Application for a non-material amendment following a grant of planning permission.
Town and Country Planning Act 1990

Reserved Matters to application 06/00967/OUT - Provision of Local Centre to include Community Centre (Class D1), Youth Centre (Class D1), Nursery (Class D1), Convenience Store (Class A1), 4 x retail units (Class A1/A2/A3/A4 and/or A5), employment units at first floor (B1a) and associated development including public square, landscaping, car parking, recycling point and ancillary servicing.

Proposed amendment to boundary treatment, additional double door to first floor and introduction of Laundry Room/Plant Area to second floor.

Scale: 1:100 @ A1	Date: 19.10.17
1:200 @ A3	
Drawn: JC	Checked: -
By: -	
Dwg No: 17-152-P-12	Revision: -

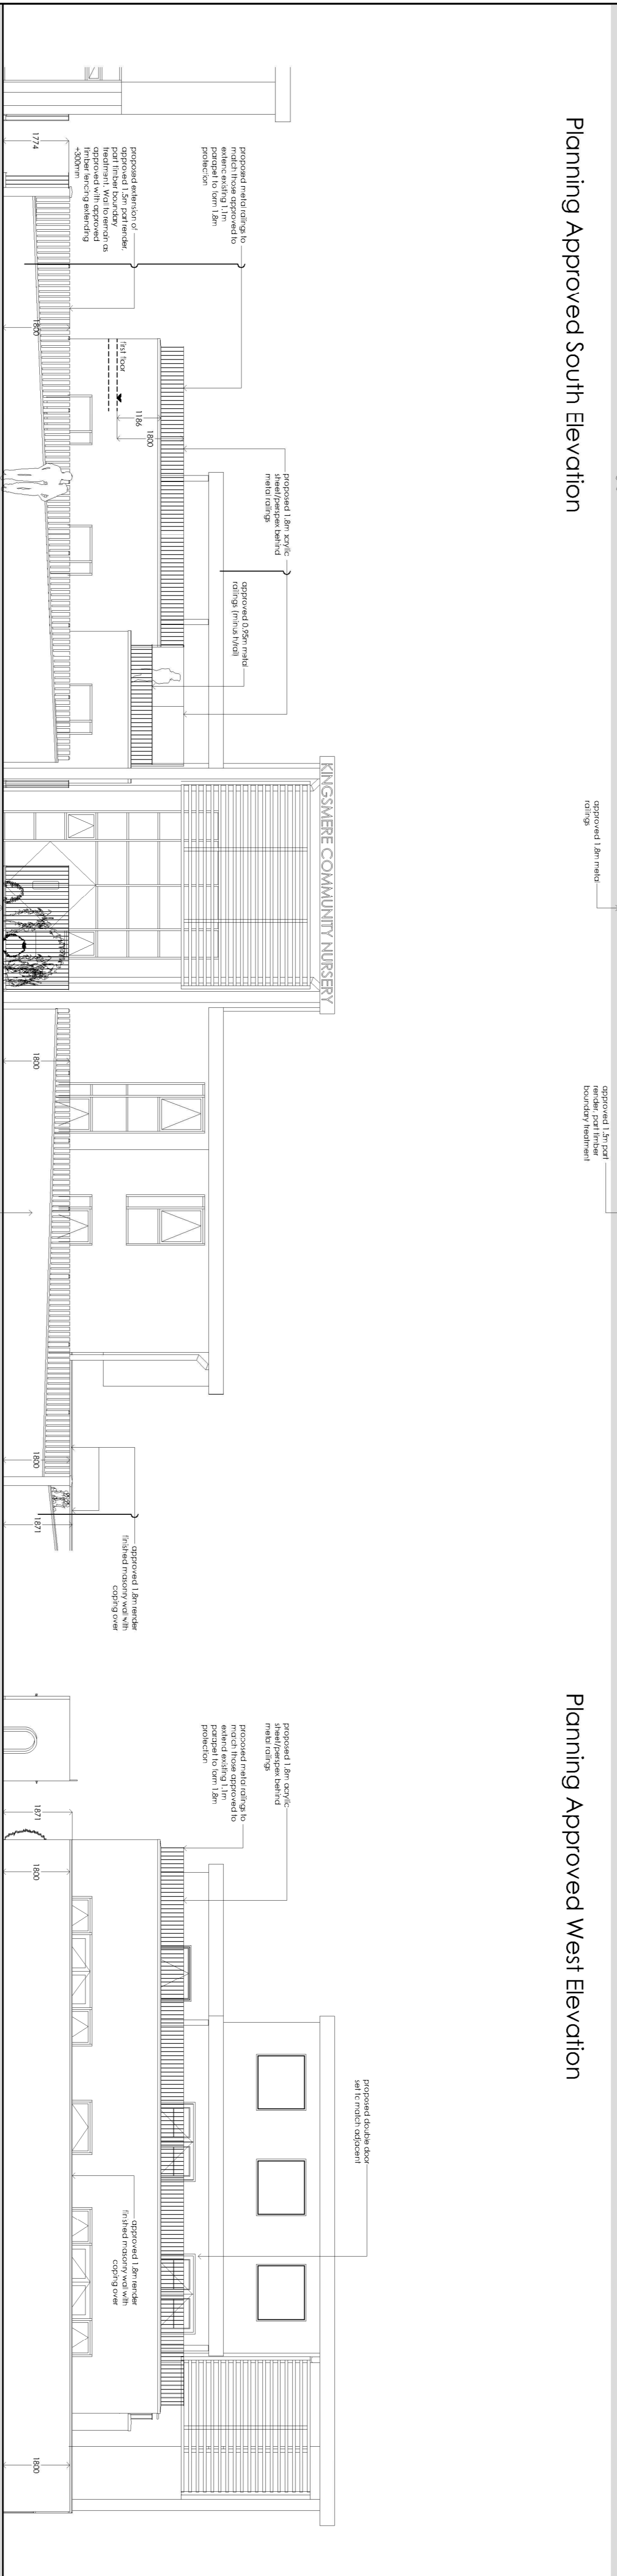
The LPA have no objection in principle to the boundary enclosures indicated on Drawing Refs : 17-152-SK-06 & 07 (now renumbered as 17-152-P-12 & P-13) , Elevation Amendments - planning application required to gain consent for the amendments.
